## Application for a Non-Material Amendment Following a Grant of Planning Permission

The application site is currently a building site

53 C Joy Lane

Whitstable

TITLE  
SECOND FLOOR & ROOF PLAN AS PROPOSED

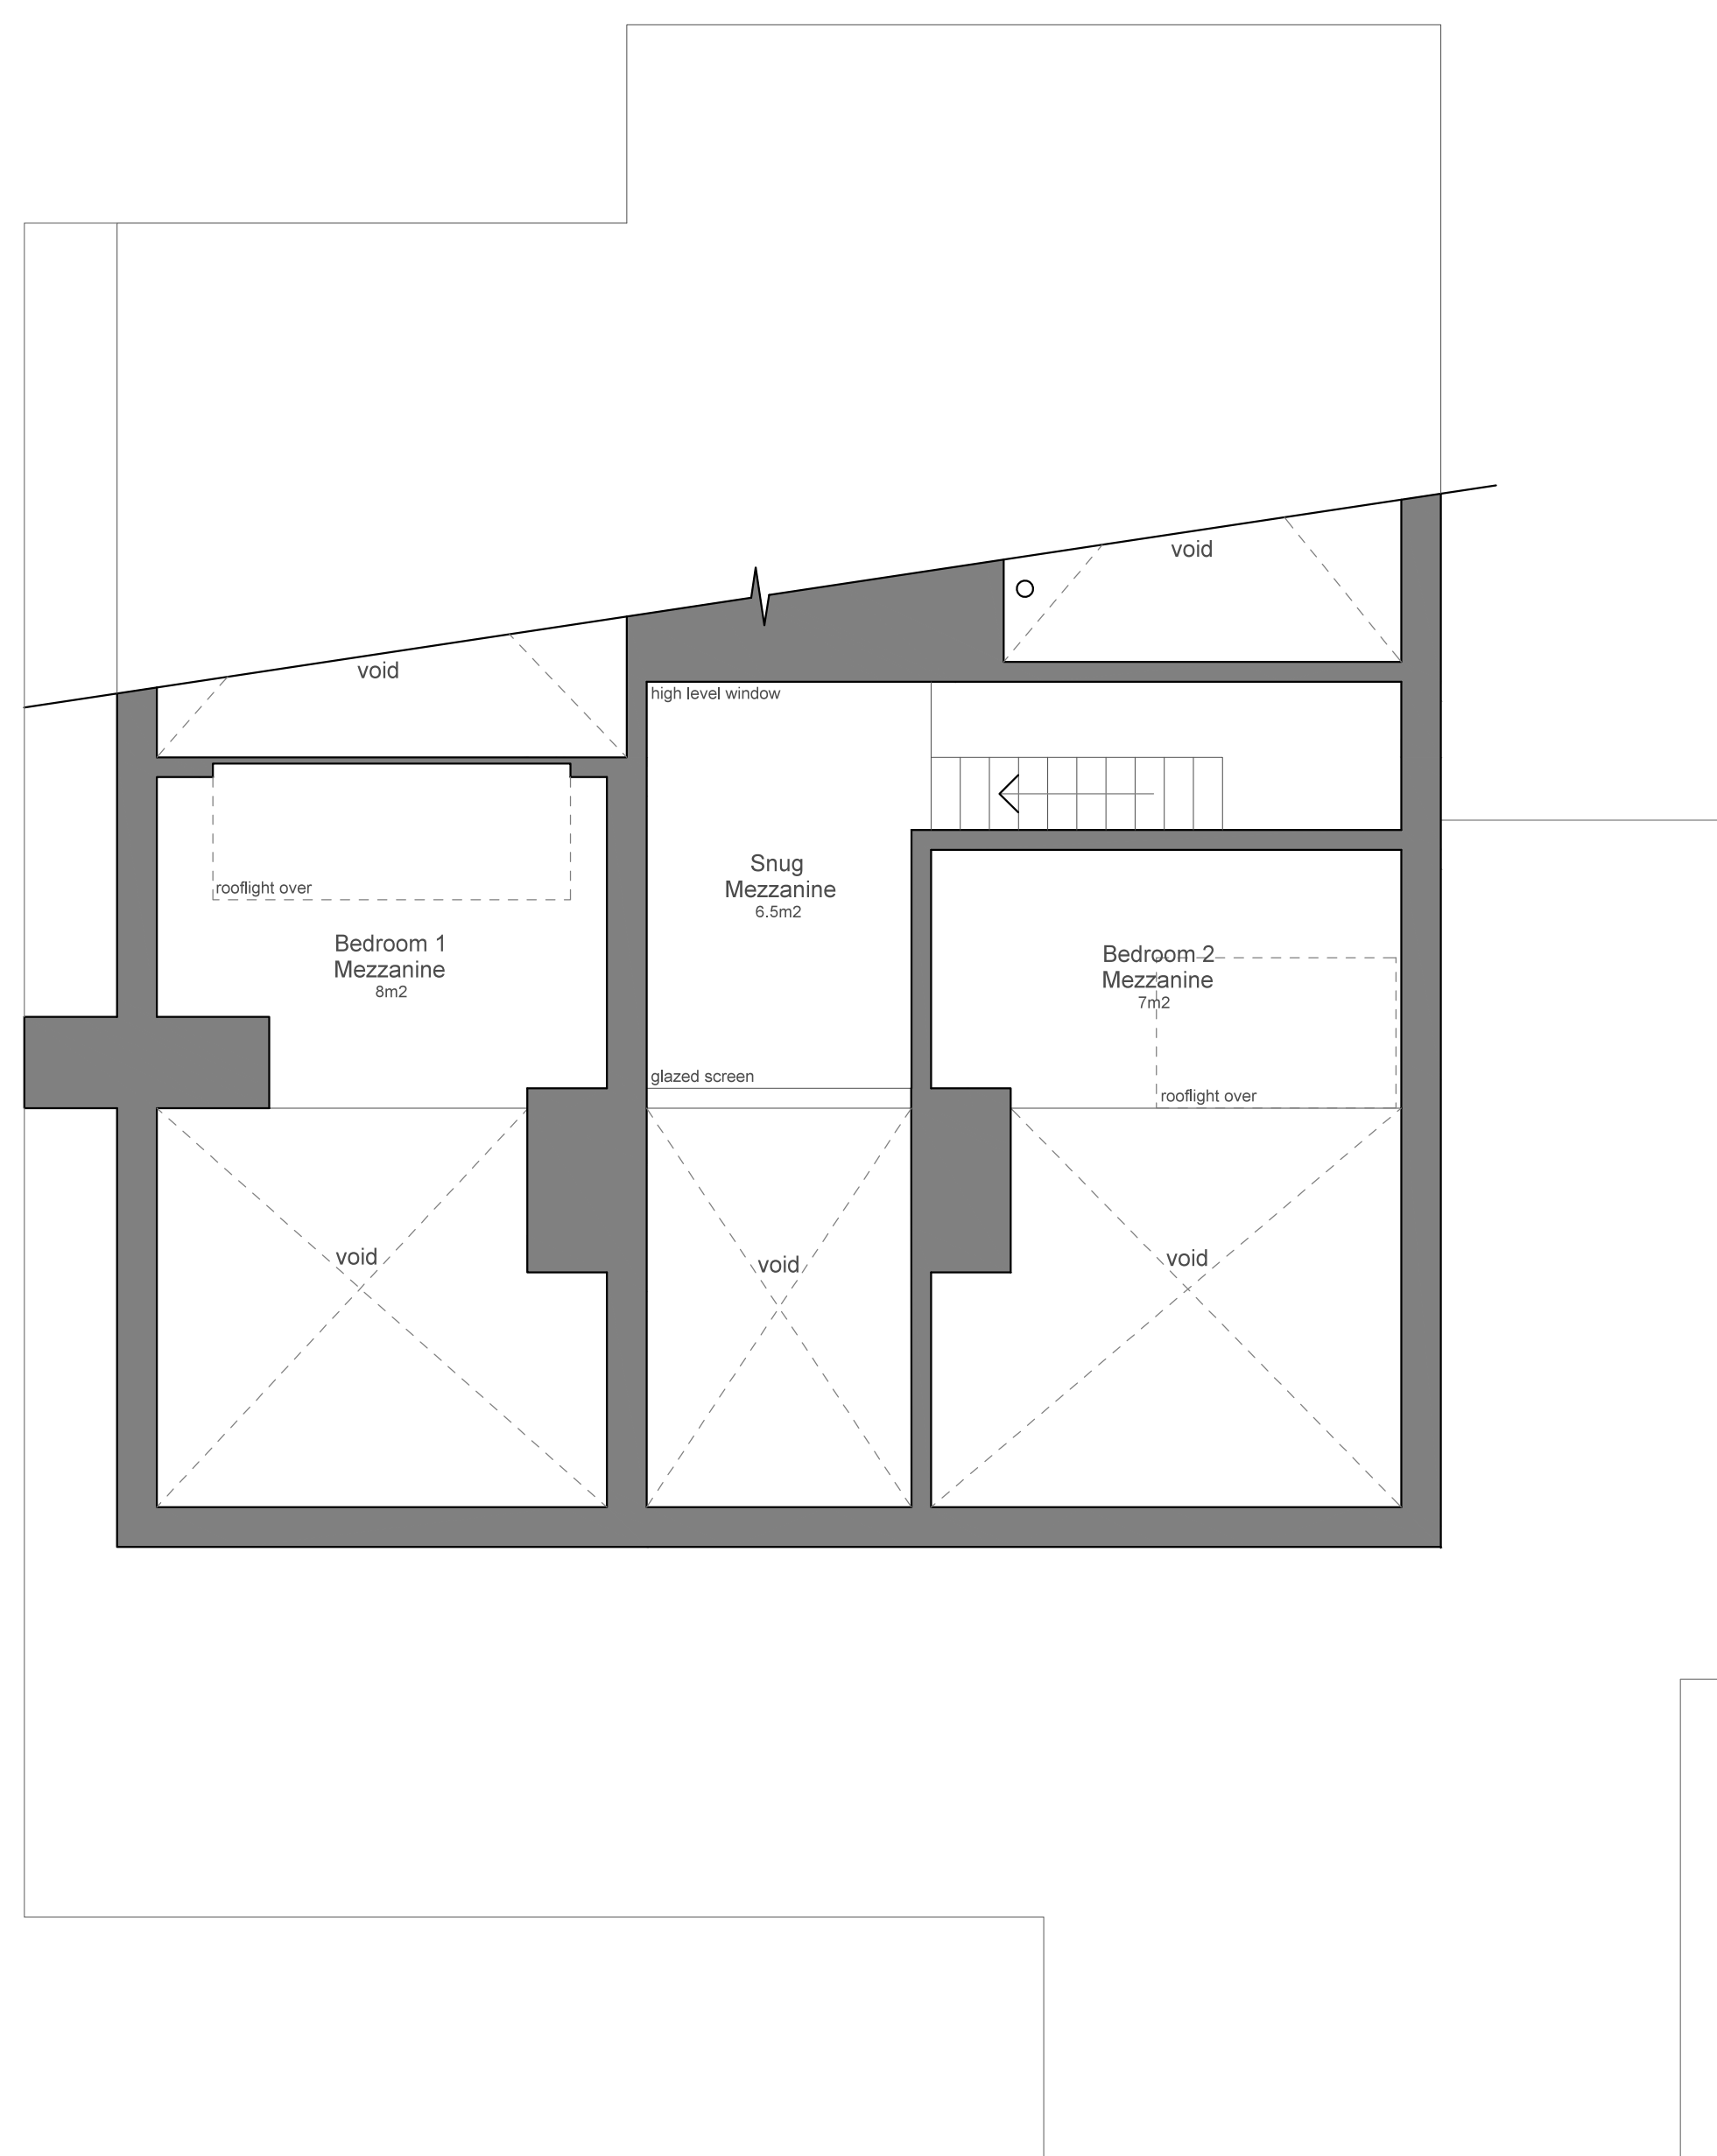
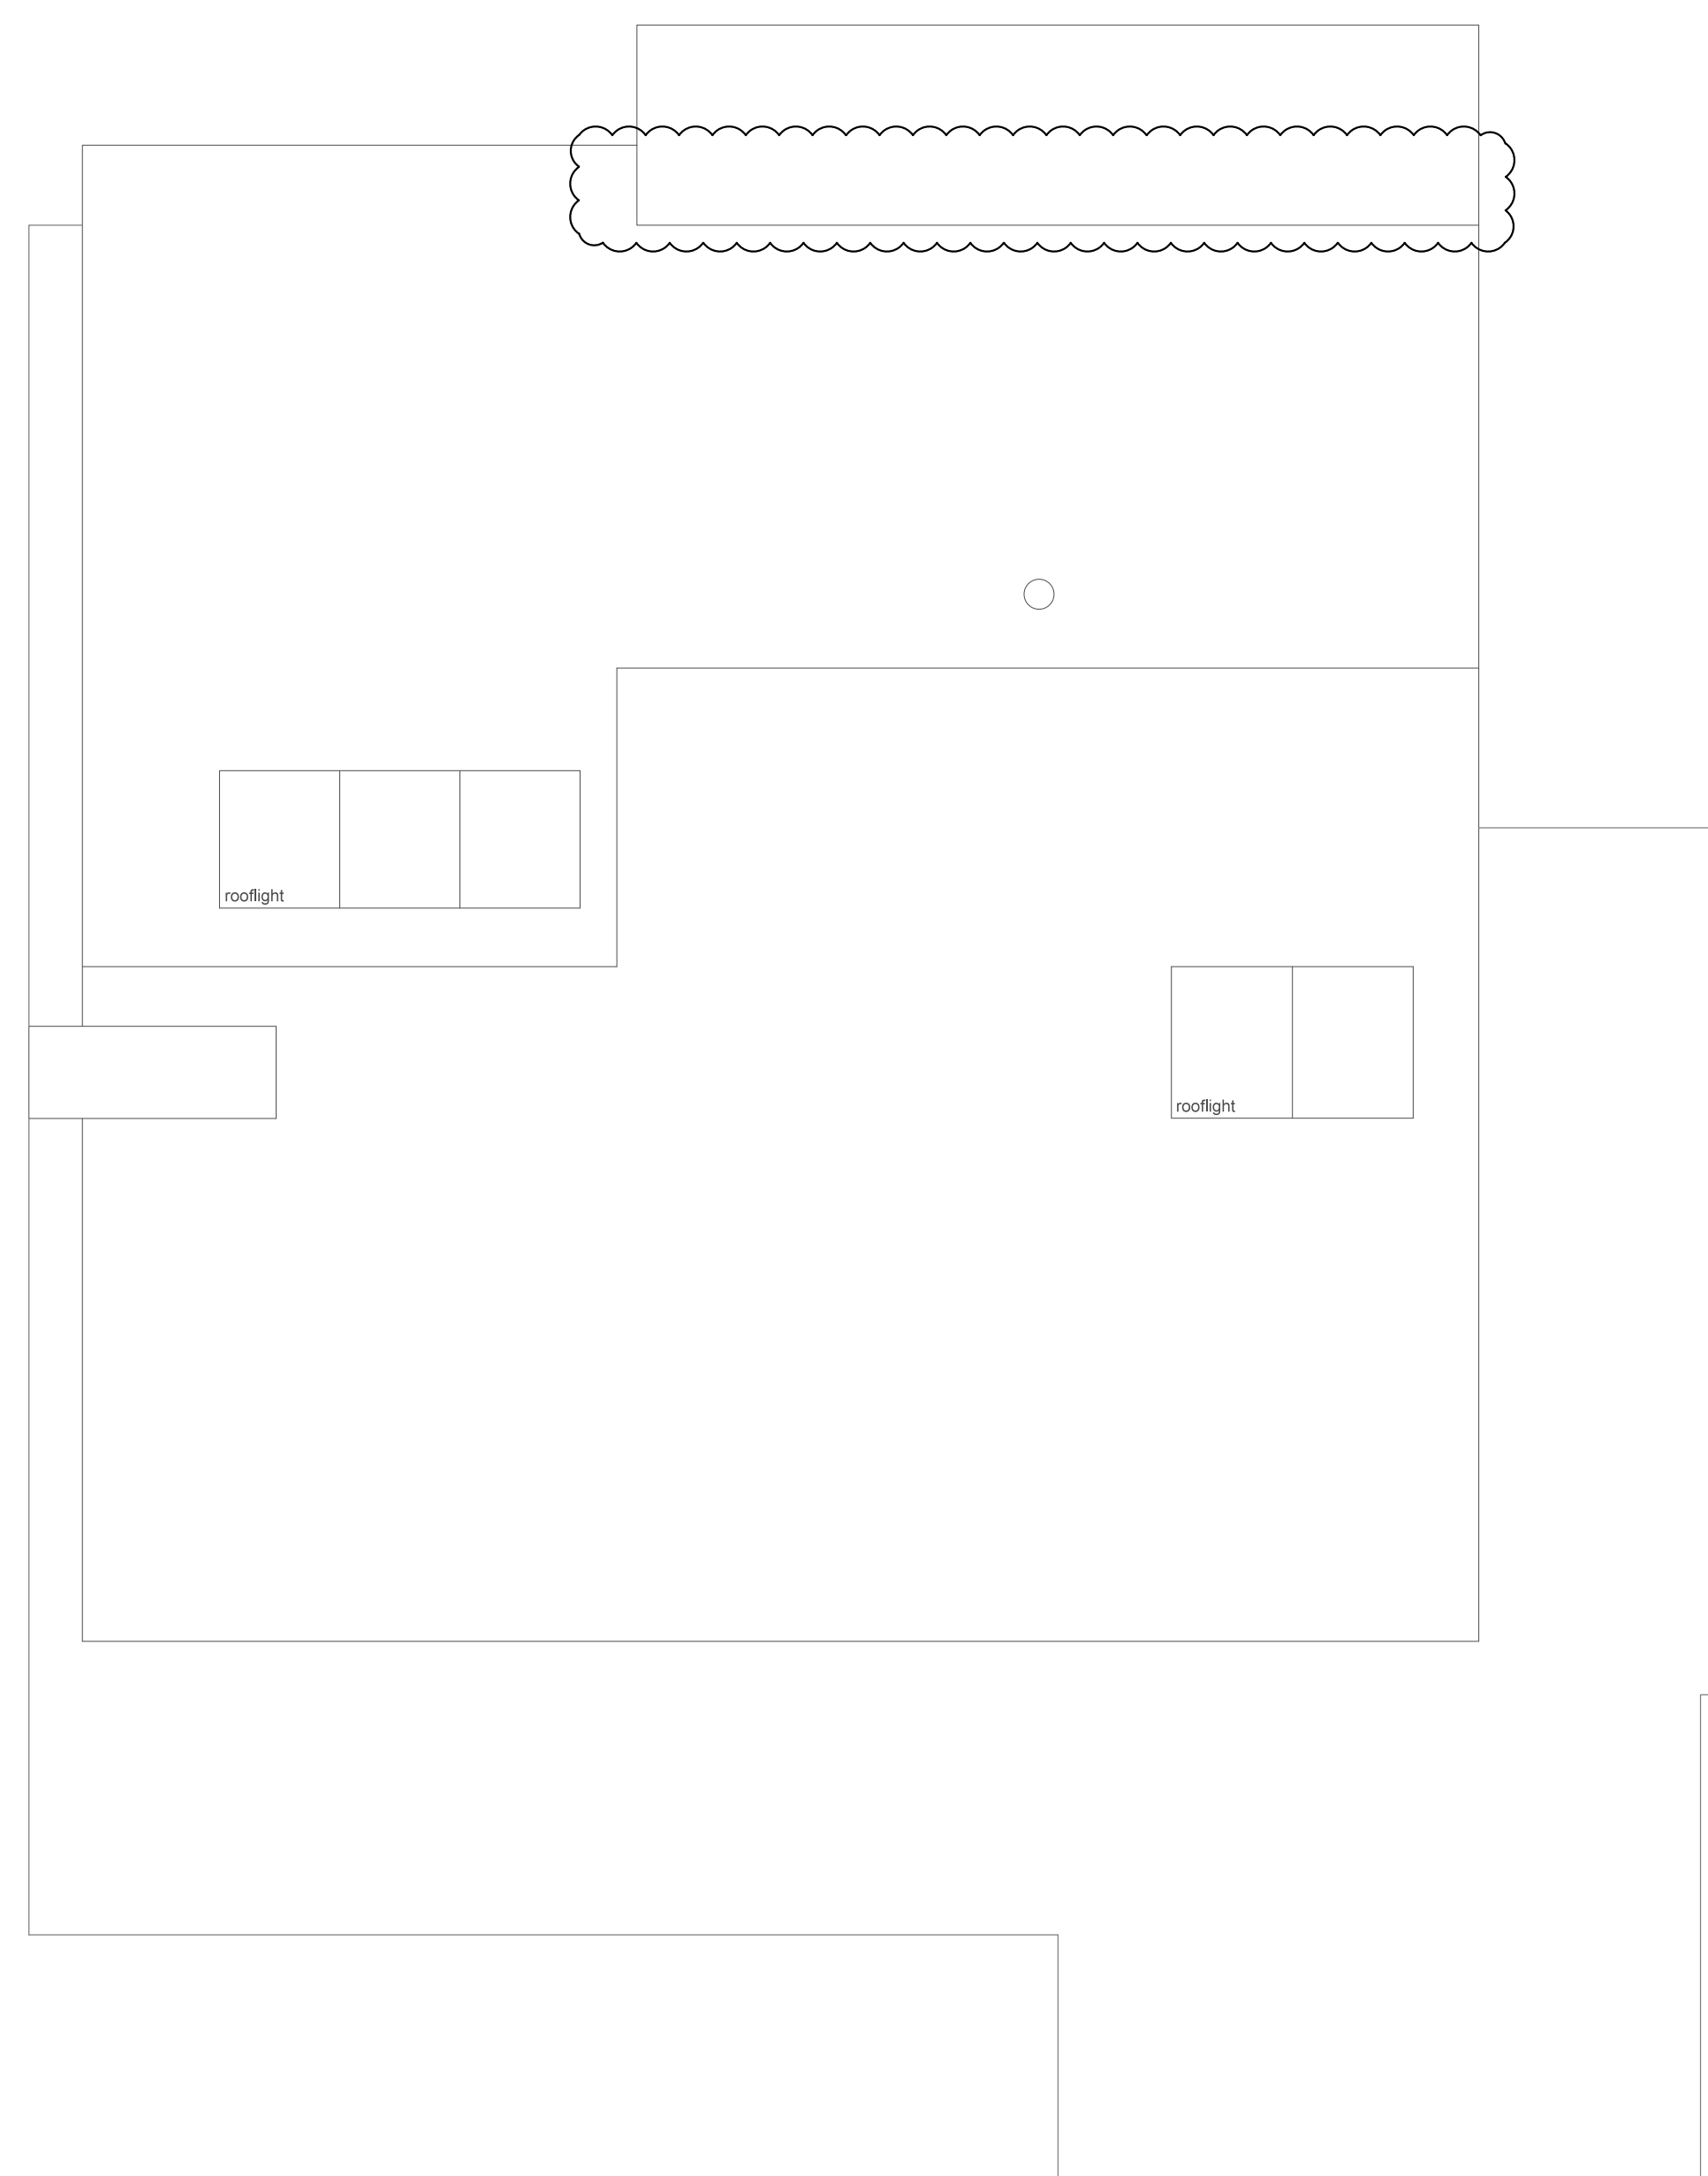
The additional of the 2no. additional rooflight will provide better natural light and ventilation into the property. There are no issues of overlooking. They will match the size / colour of the approved rooflights.  
A reduction in the pitch of the roof over the 1st floor balcony will improve the views to the sea.
